**KIRKLEES METROPOLITAN COUNCIL  
INVESTMENT & REGENERATION SERVICE**

**DELEGATED DECISION TO DETERMINE PLANNING APPLICATIONS**

Reference No:	<b>2023/62/91433/W</b>
Site Address:	27, Crosland Fold, Lindley, Huddersfield, HD3 3QH
Description:	Erection of two storey rear extension
Recommending Officer:	Tom Hunt

## HOUSEHOLDER DELEGATED REPORT

Drawing
Block Plan & Location Plan.

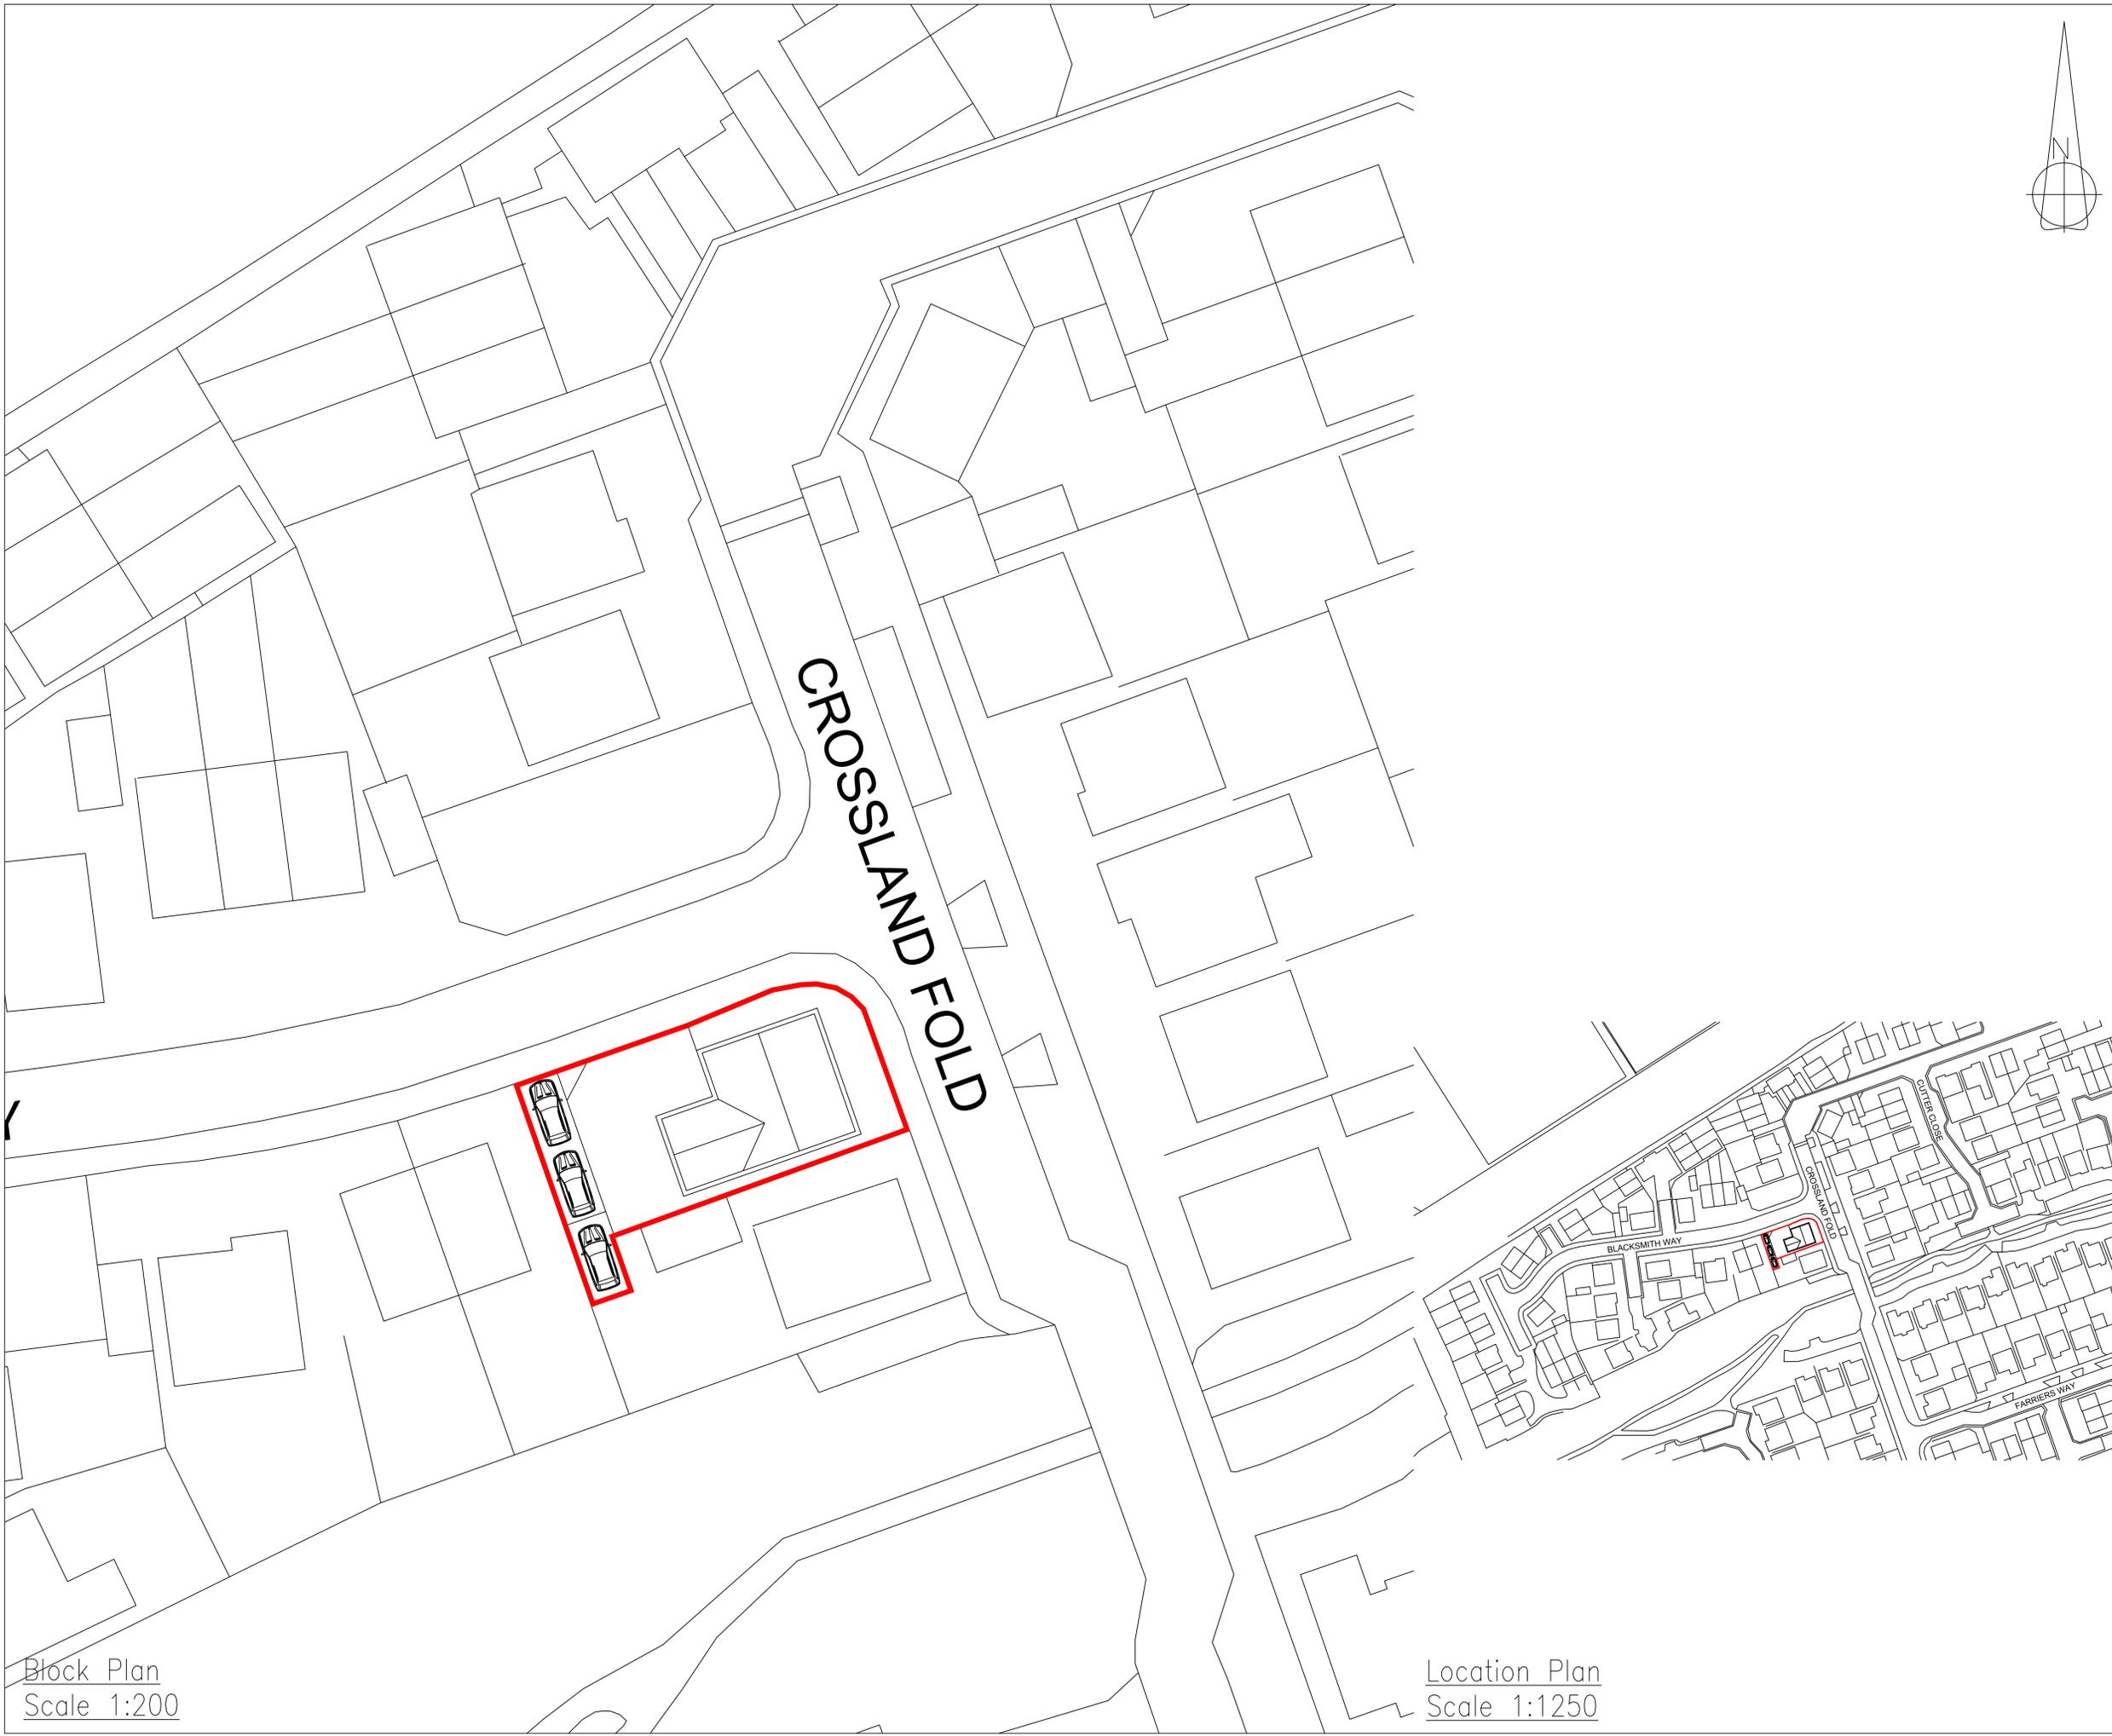
This would extend 4m from the rear and be 5.625m width set back from the prominent flank elevation of the property by 3.15m. It would be hipped roofed with its ridge set 0.2m from the host and eaves to match. This would have window and patio doors to its northwest flank elevation; windows to the rear and a door entrance inserted to the southeast flank elevation. Rooflights will be arranged either side of the roof of the extension. This would serve a snug at ground floor and bedroom, wardrobing area and shower-room to first floor. The proposal would reconfigure rooms within to add an office but no additional bedrooms. Parking layout has indicated tandem parking for three vehicles.

Proposed Floor Plans

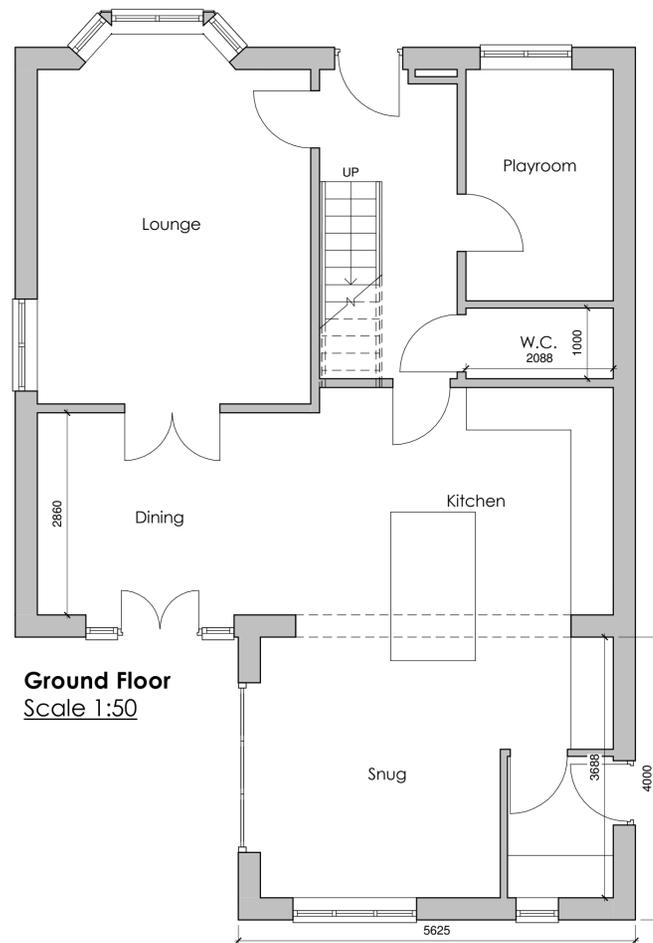
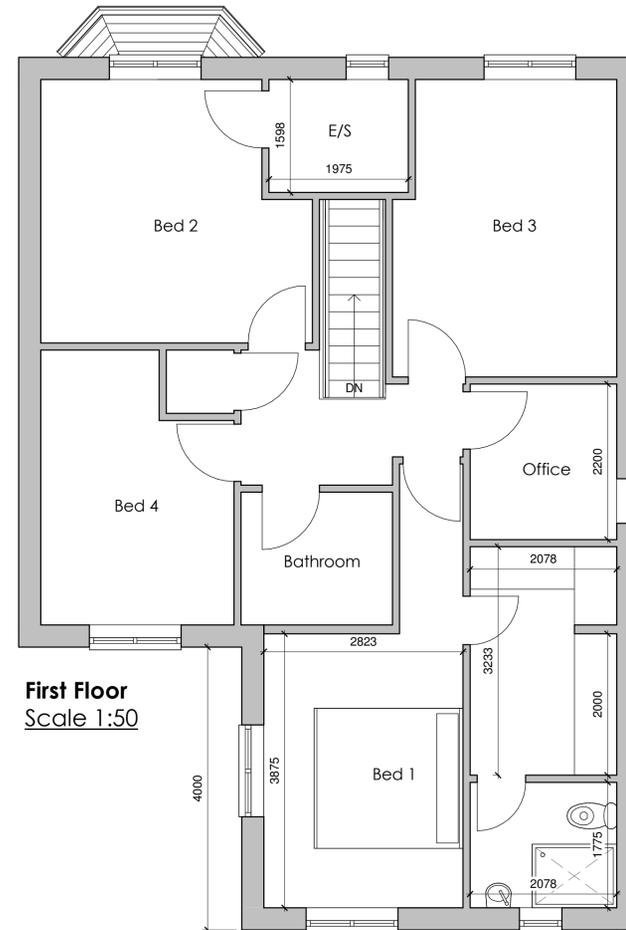
A new window serving an office will be inserted to the first floor of the host towards the rear.

<p>not exceed a height at the eaves of 3 metres where the extension is within 1.5 metres of the property boundary</p>		<p>No – extension would be within ~0.9m of closest boundary to southeast. This is similar to the host and the neighbour would not suffer loss of outlook due to its distance away from the host and would not suffer undue overshadowing being positioned northwest of the closest neighbour. In addition a steep pitched detached garage to the neighbouring property would serve to partially screen the proposed extension to avoid appearing overbearing. Acceptable.</p>
<p>be separated from the property boundary, such as a wall, fence or hedge, by at least 1.5 metre</p>		<p>No – As above. This would also be separated adequately (3.15m) to the highway so as to avoid detrimental visual impacts to the streetscene of overbearing.</p>
<p>not adversely affect habitable room windows where they adjoin a neighbour's boundary</p>	<p>Yes</p>

- *25 Crosland Fold. Its single-storey, detached garage is positioned next to the proposed extension partially screening the proposal. Extension is set at a sufficient distance northwest and has a hipped roof design to adequately avoid additional material overshadowing or loss of outlook to the neighbour. The new office window at first floor will mostly face a blank side elevation of no. 25 and be acceptable for avoiding overlooking or loss of privacy.*

- *1 Blacksmith Way. The extension's openings would face its flank elevation which has an obscure glazed window to first floor and the extension's bulk and massing would be positioned with a separation distance of ~11.5m to this elevation.*

- *2 Blacksmith Way. The extension would be ~16m distance to the southwest of this neighbour which has windows facing to no. 2's primary elevation. The extension would have a window to first floor serving no. 27's bedroom which is a habitable room. It does not have a planning history or a recent sales record to indicate whether the windows facing serve habitable rooms. Whilst this may not fully comply with the minimum of 21m between habitable rooms under paragraph 4.10 of the House Extensions and Alterations SPD, Officers proposed that this be acceptable as it would have oblique views looking out to the flank elevation of the opposite neighbour and it would principally be a bedroom to bedroom relationship.*
